Paul and Cathy Hartmann  
13760 Bandanero Drive  
Peyton, Colorado 80831

18 Jan 2019

Reference: Meadowlake Ranch Sketch Plan, Project File No. SKP184

SKETCH PLAN

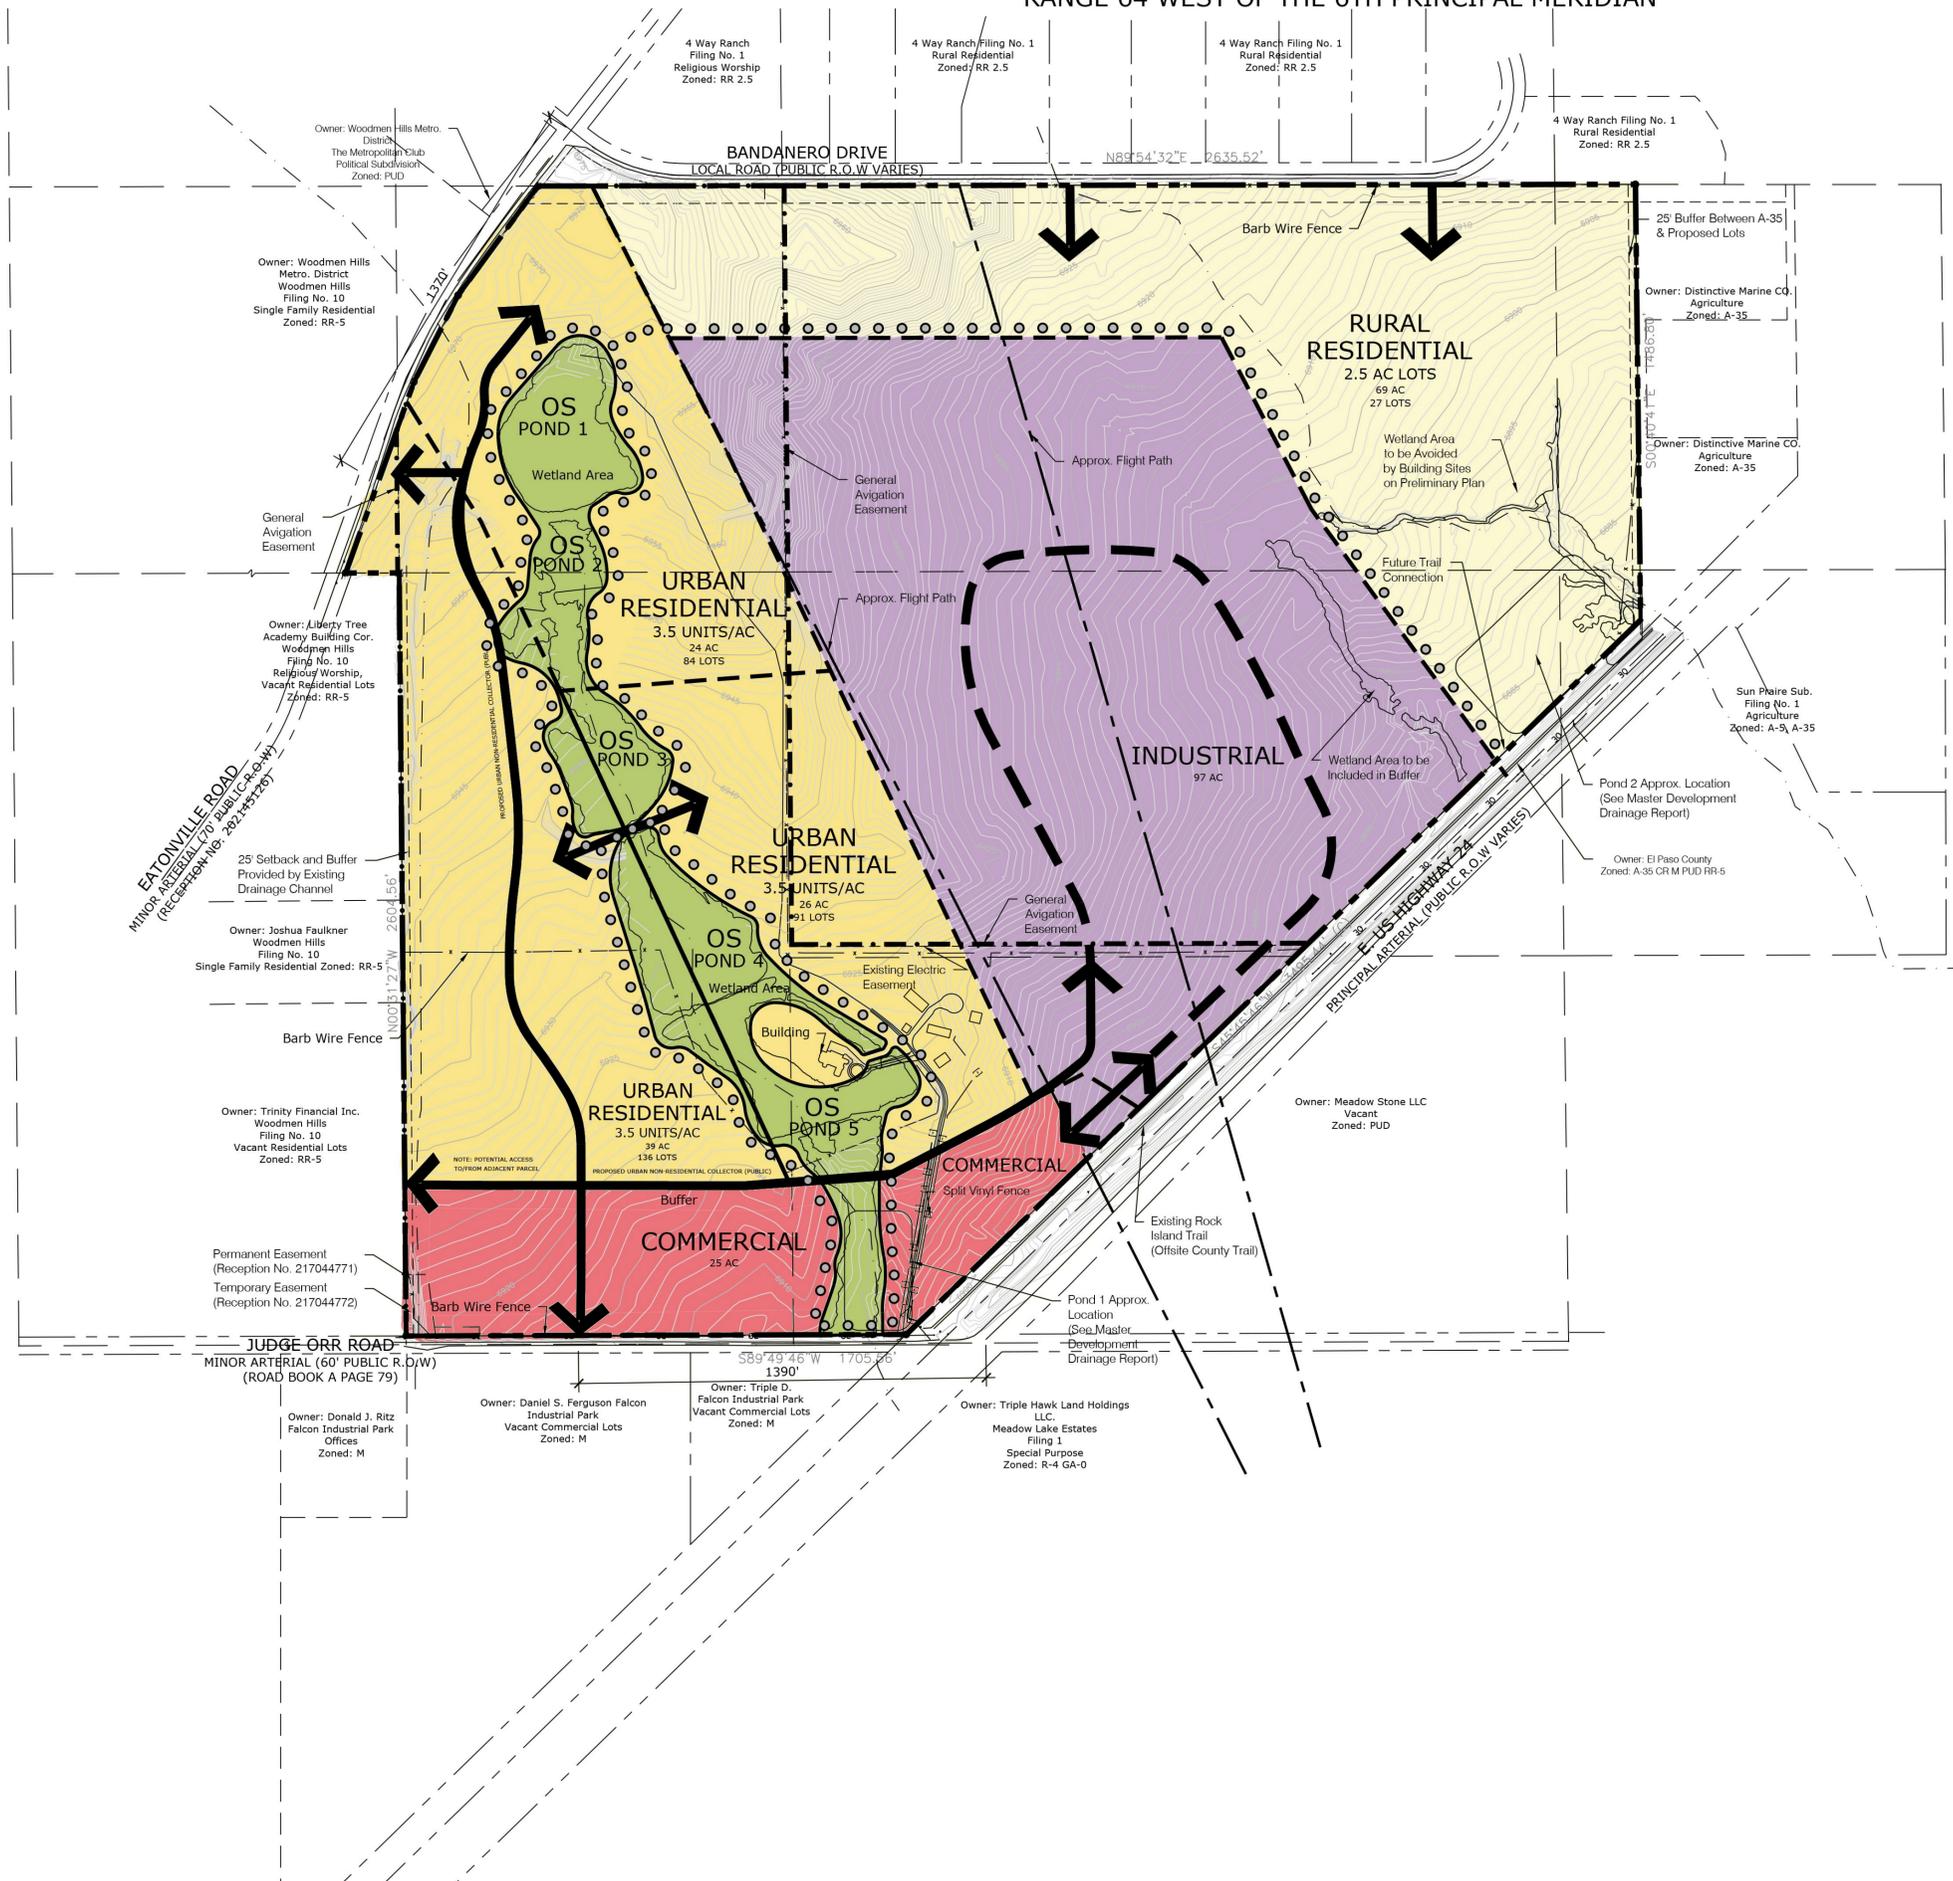
Within the proposed Meadowlake Ranch Urban Residential Area (near the easterly boundary) a ridgeline establishes the natural viewshed. Breaking that ridgeline will impact the viewshed and fail to meet the FPSAMP goal to “Preserve the visual resources that are unique or are considered part of the identity of the planning area”.

- Place open space along the ridgeline.
- Align an internal road or rear property line with appropriate set-backs.
